RE: Short plat application: SP-25-000012 Clear View

Subject: SP-25-00012 Clear View - Notice of Application

TO: All Staff
FROM: Public Works Plan Review Team
DATE: December 19, 2025
SUBJECT: SP-25-000012 Clear View

CLEAR VIEW SHORT PLAT, SP-23-XXXXX
SPF-23-XXXXX
 WITHIN THE W1/2 OF THE SW1/4 AND THE SW1/4 OF THE NW1/4 OF SECTION 1,
 TOWNSHIP 19 NORTH, RANGE 14 EAST, W.M., KITTITAS COUNTY, WASHINGTON

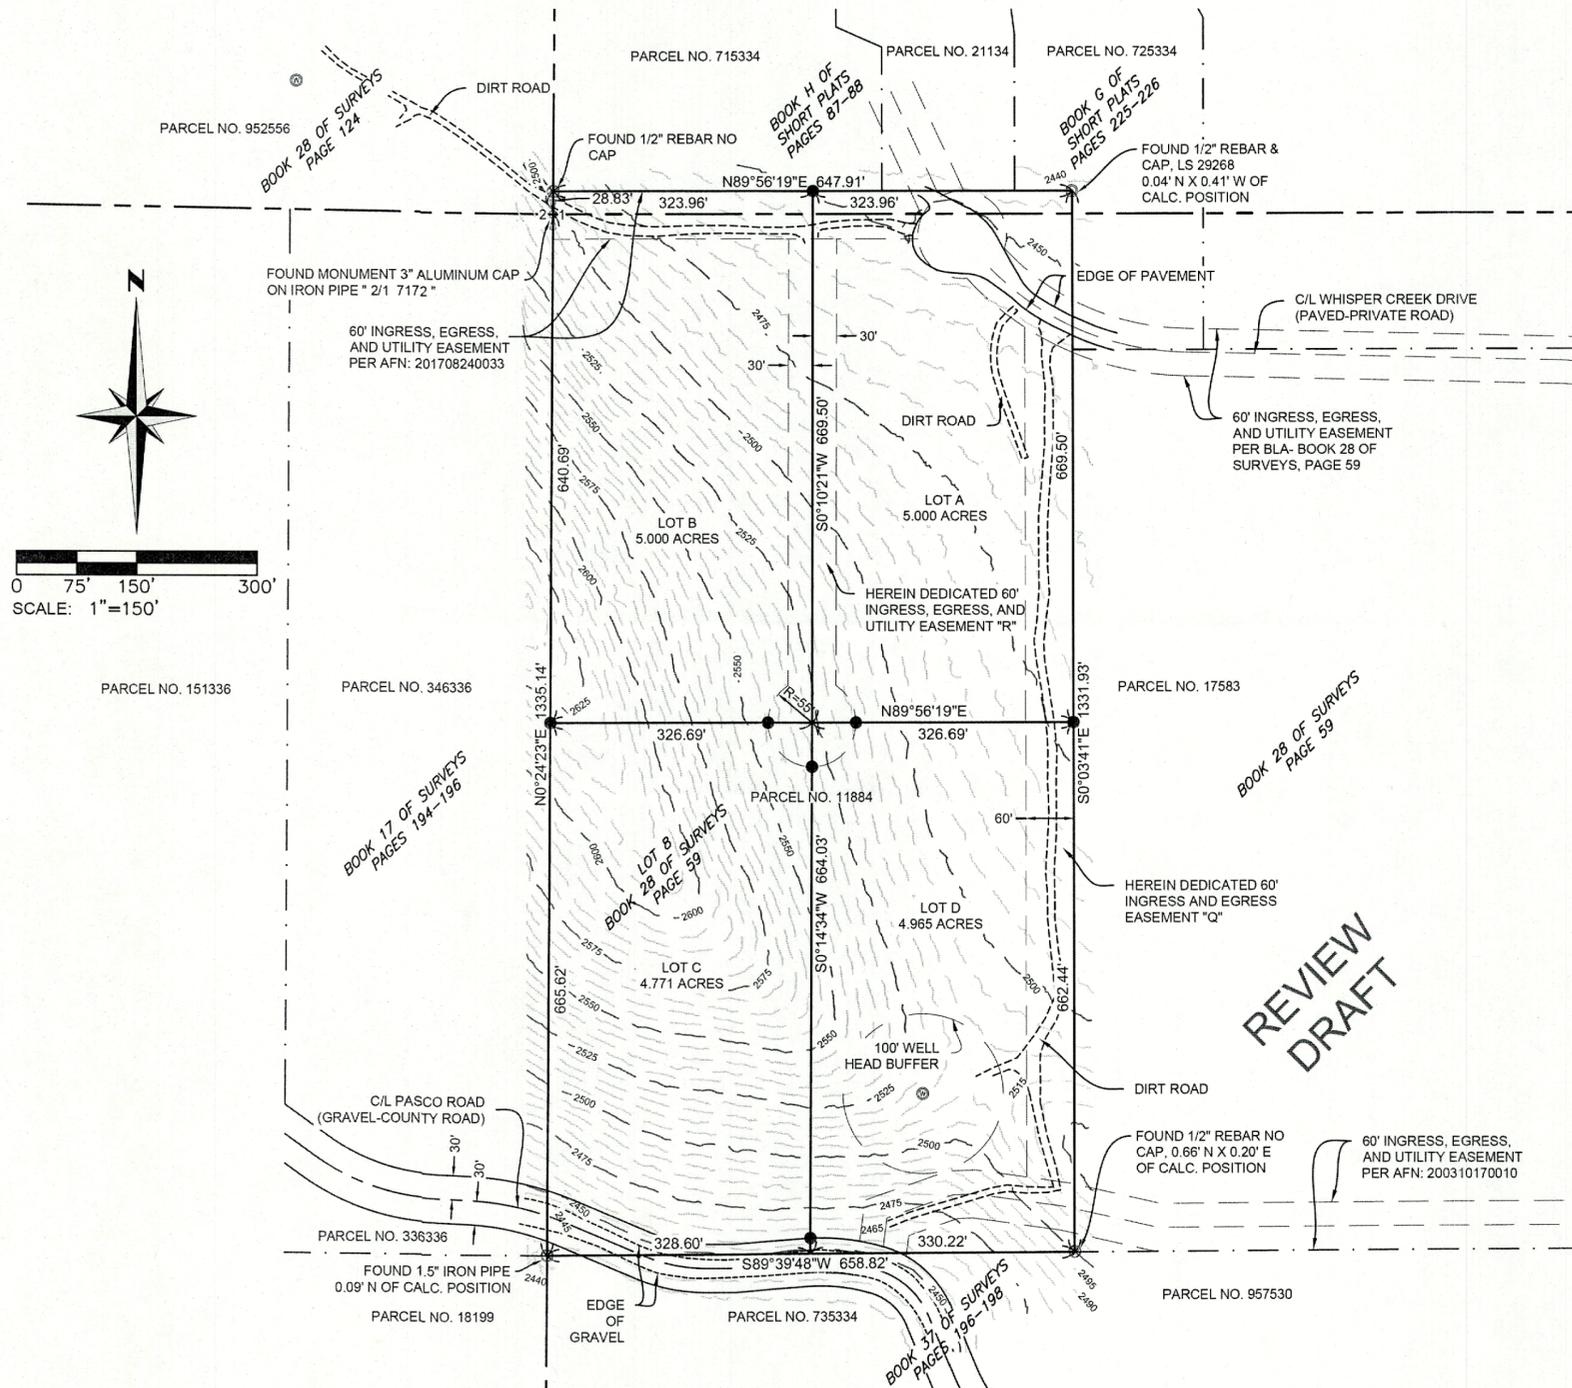
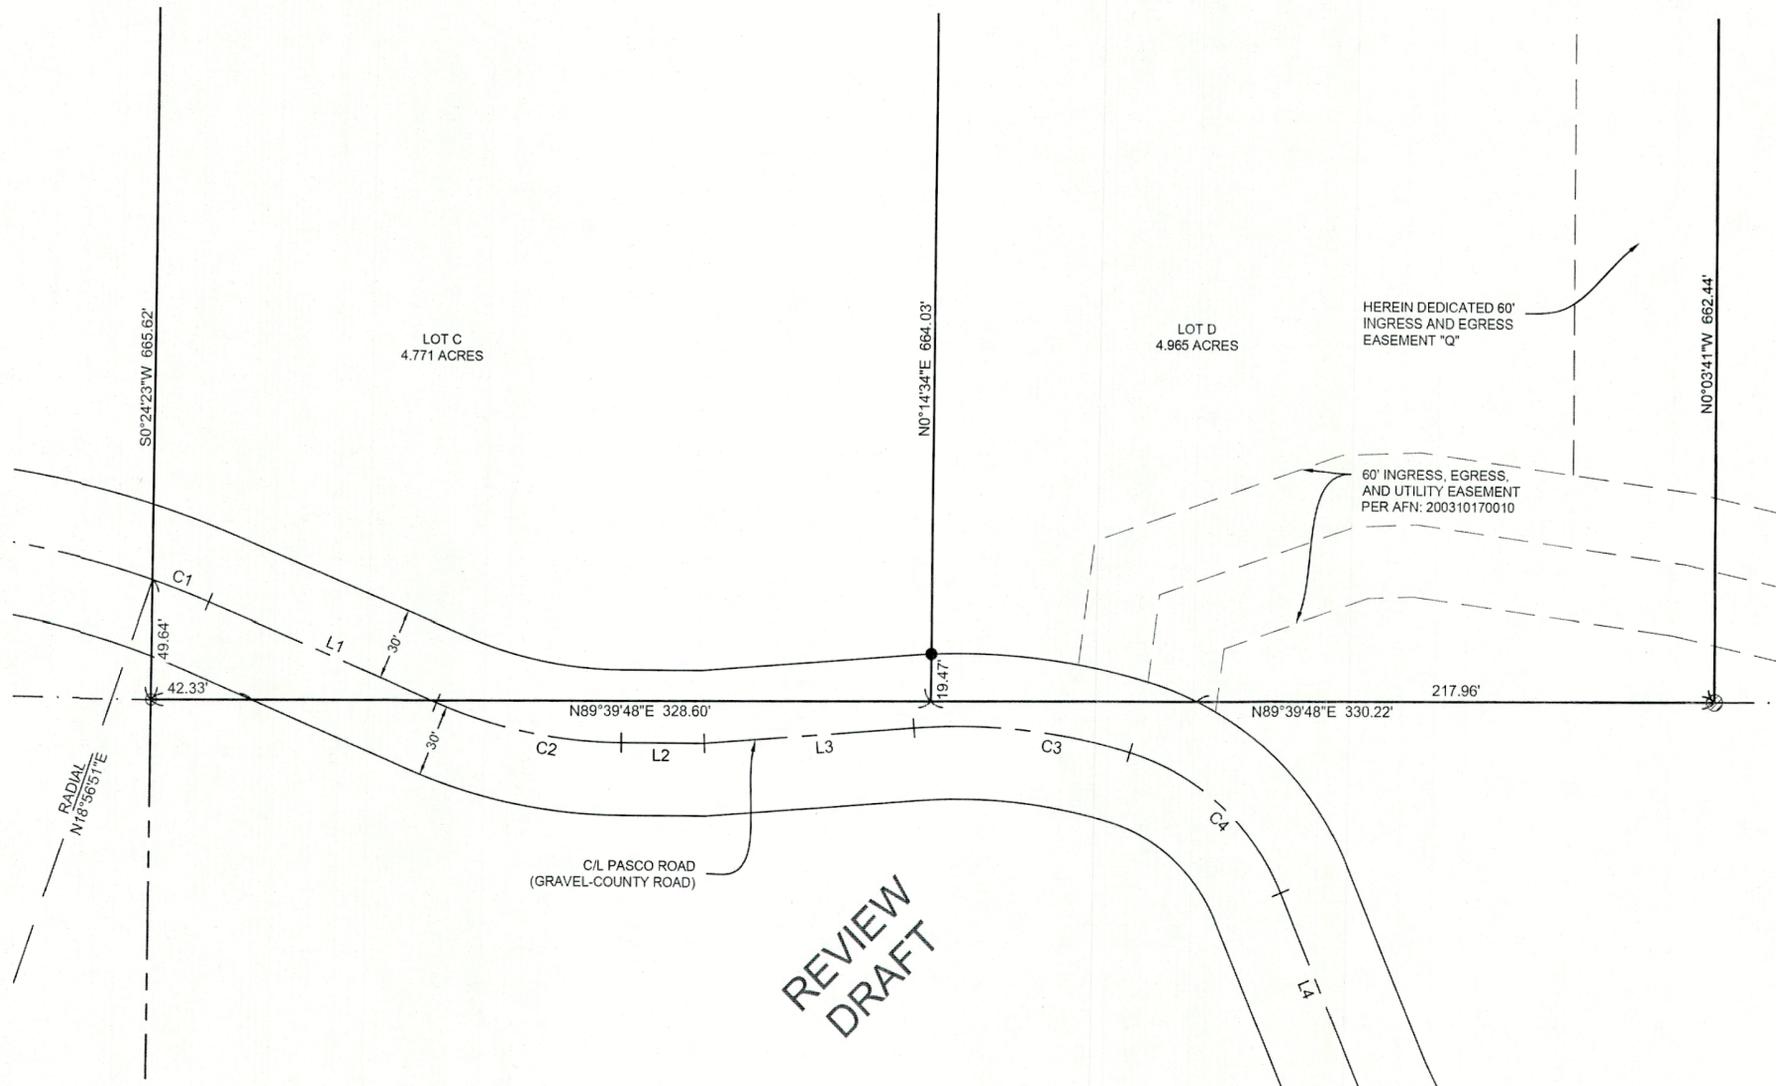
The Bonneville Power Administration (BPA) has reviewed the above-mentioned proposed plat and its relationship to the BPA 14-foot-wide access road. BPA does have some concerns with the activity that may occur within the short plat (Plat - Project Number SP-25-000012) and the proposed lots (numbered C and D) intended for residential use.

In order to avoid problems in this location and to notify prospective landowners, BPA requests that the language be included on the plat map:

The Bonneville Power Administration (BPA) imposes certain conditions on the portions of those properties encumbered by its high voltage transmission line right-of-way and access roads. BPA does not allow structures to be built within the right-of-way, nor does it allow access to be blocked to any transmission facilities. Any activity that is to occur within the right-of-way needs to be permitted by BPA prior to installation or construction. Information regarding the permitting process for proposed uses of the right-of-way may be addressed to BPA Real Estate Field Services at (800) 282-3713.

TYPICAL 2NDARY ACCESS SECTION
SCALE: 1" = 5'

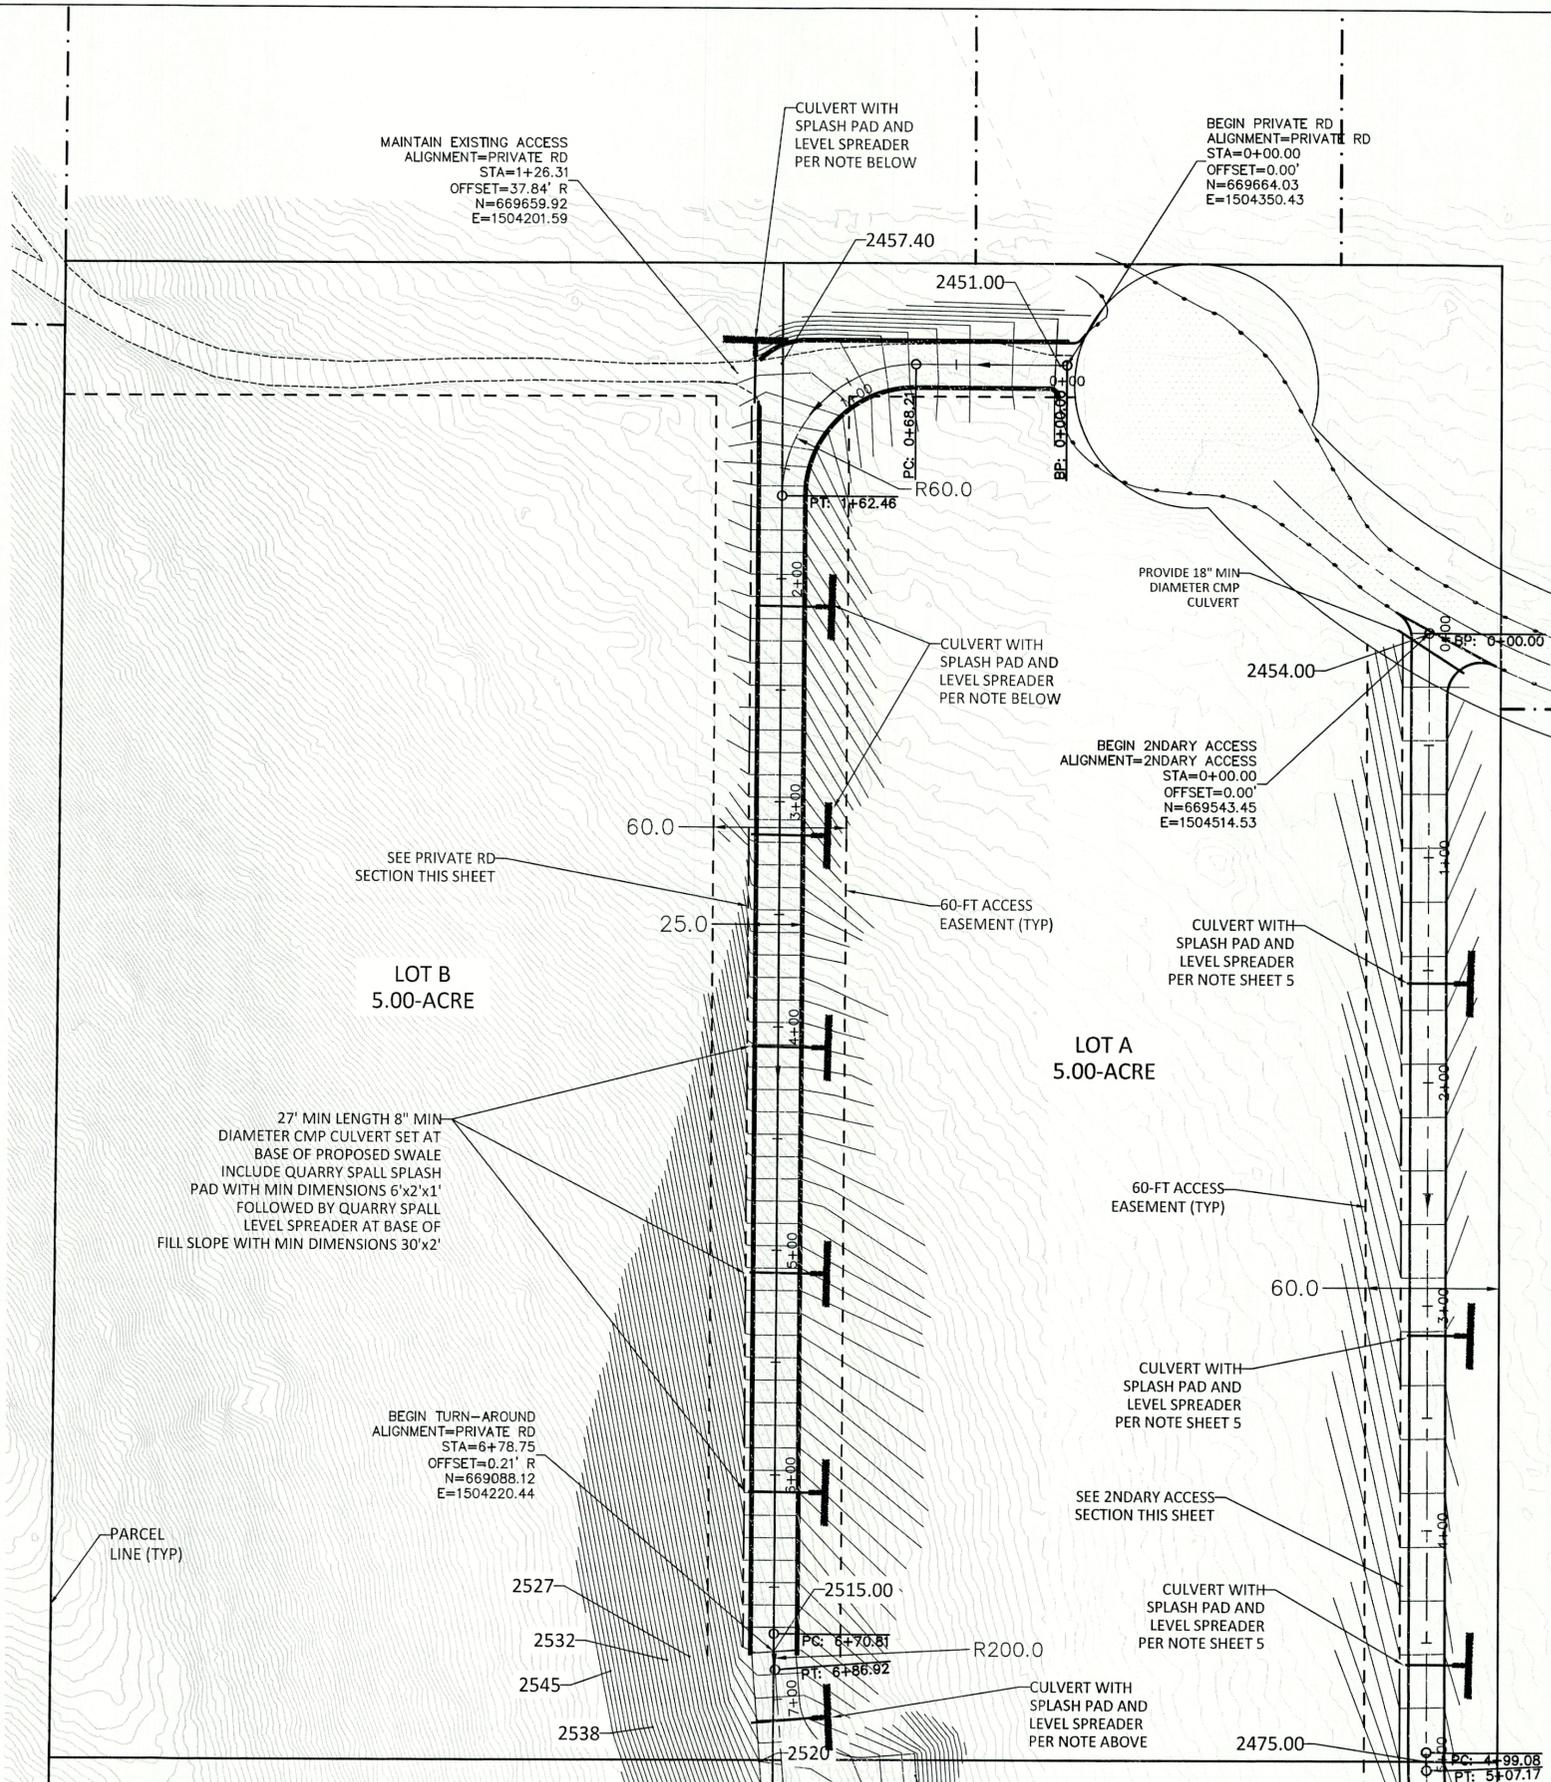
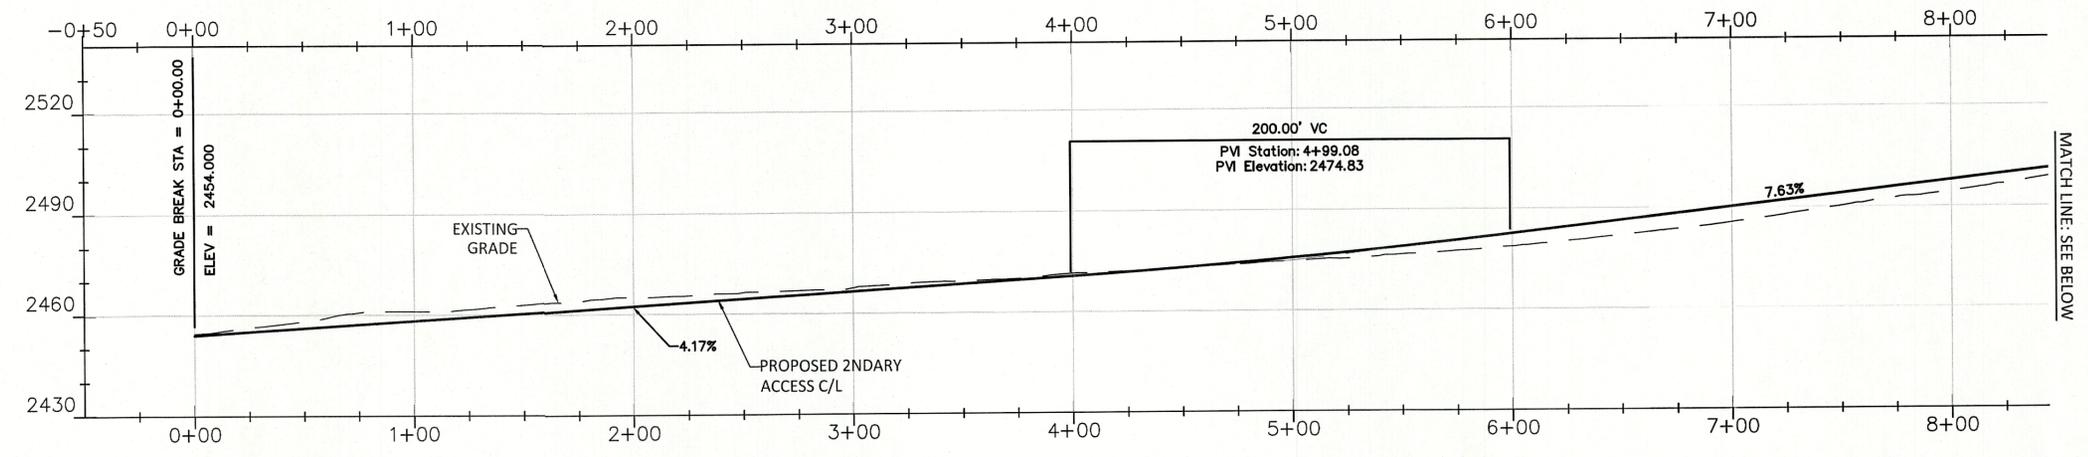
DAHP's predictive model suggests this area is at moderate risk for cultural resources to be present, and advises survey. Given the proposed access improvements to the plat which include grading and the placing of culverts and impermeable surfaces (roads), as well as in the interest of streamlining future development efforts on these lots, we would concur and recommend that a full cultural resource survey with an appropriate subsurface testing schema be carried out ahead of project implementation. We would also request a copy of any report produced as a result of such an effort. An Inadvertent Discovery Plan would also be very appropriate for the ground disturbing work proposed.

I had understood that a secondary access road needed to be completed and approved prior to subdividing lots in that area. Could you clarify the specifics on that requirement, especially in relation to the Clear View Short Plat (SP-25-00012)? I'm hoping to get clarification on that situation for future planning considerations.
